## 21 Salem St - Permit #1416

Tracie Reed <traciereed@dextrouscreative.com>  
To: Christina Stacey <cstacey@portlandmaine.gov>

I just took a look at this application you submitted for the above property. There are a couple questions/concerns:

(B) East  
1/4" = 1'-0"

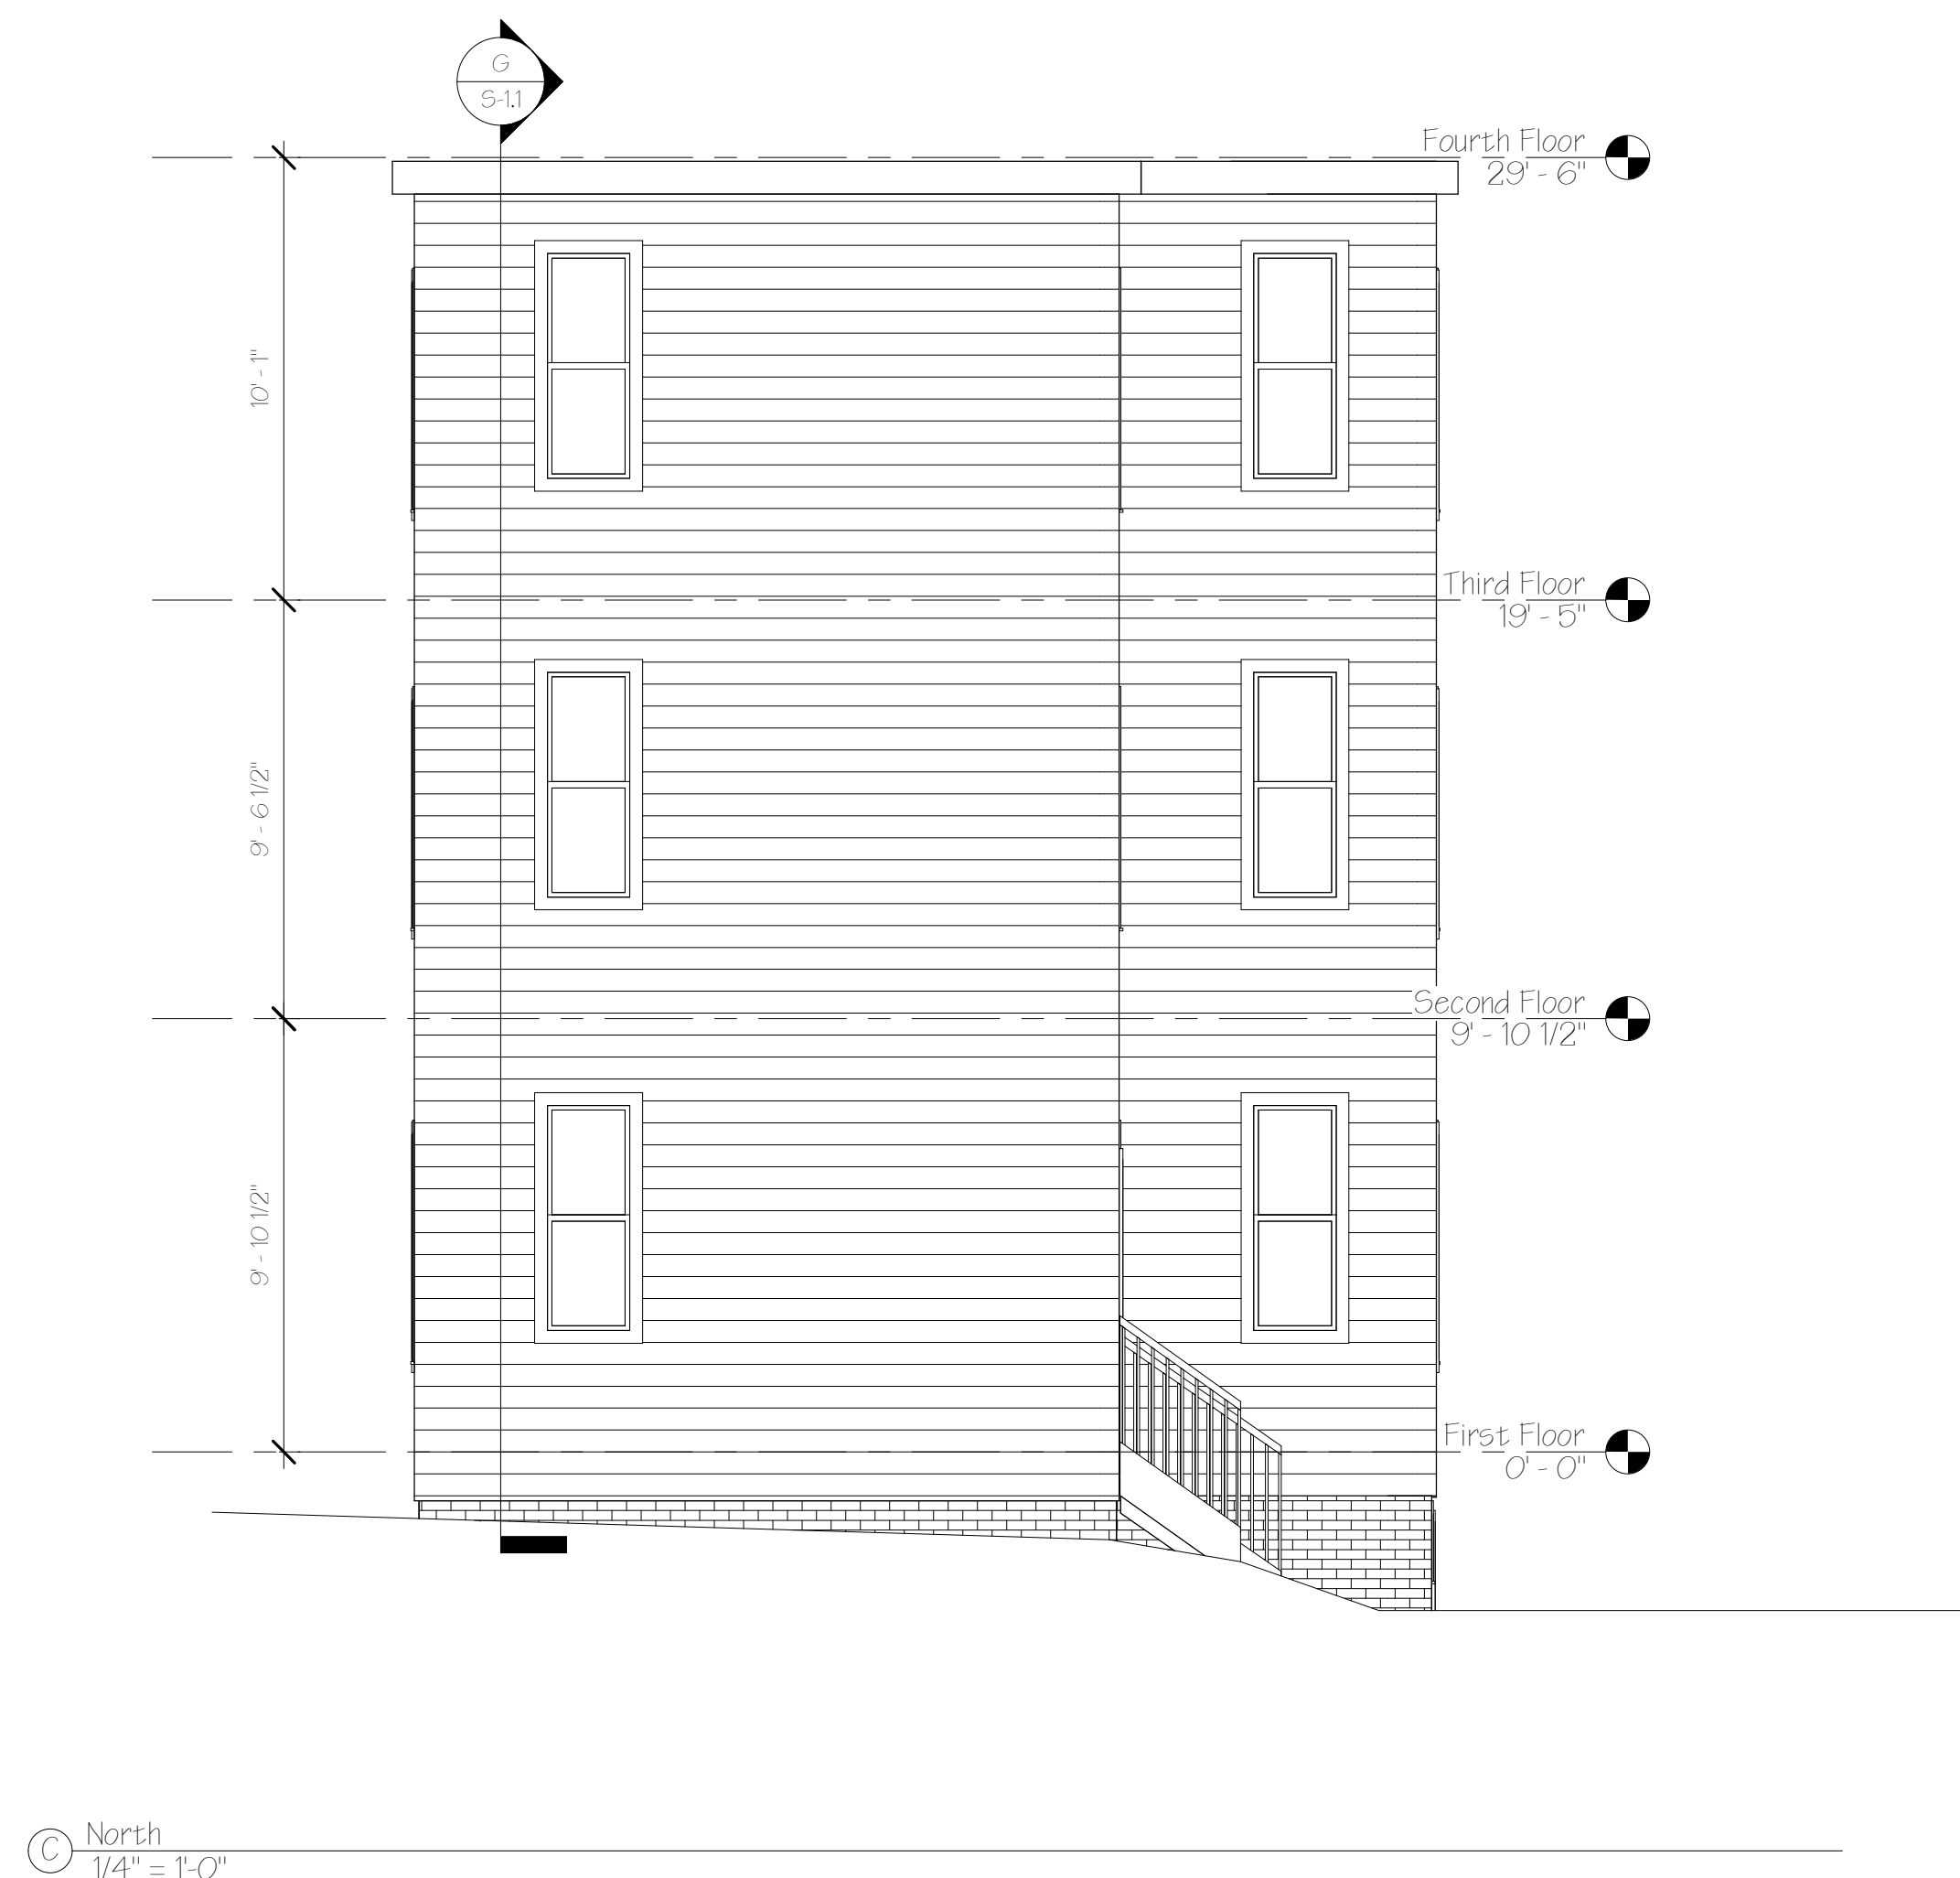
Second, the upper story balconies (particularly the third story) could present some issues for zoning. Although they are proposed to go over the footprint of the existing first floor entry, they are still considered new additions to the building and must meet setback requirements (NOTE: the second story balcony is probably actually OK since it is essentially just putting a railing around the entryway roof, which is allowed).

The front setback minimum is either 5' or the average of the setbacks of the abutting houses on either side of this house. It looks like the new balcony will be at a 0' setback. You can double check the abutters' measurements on the ground to see if your client can qualify for a lower setback using the average. If not, I think you would need to revise the plan so that the front setback of the third-story balcony is meeting whatever that average is.

Chris, Thanks for your review. At present the rise/run of the stairs do not meet current code requirements so the extension is to fulfill those requirements. In terms of the front setback you are correct that we've got a 0'-0" setback ourselves. The adjacent houses are not 0'-0" setbacks, the average may provide us a foot or so but the total depth is 6'-6" so it doesn't really seem worth it, \*ugh\* always such a tough one. Structurally and aesthetically having a tiny porch on the third porch would be very odd-looking, too.

I'll confer with my client and let you know what they'd like to do. I'm guessing there are no other exceptions to the zoning that might be helpful in terms of the third floor deck?
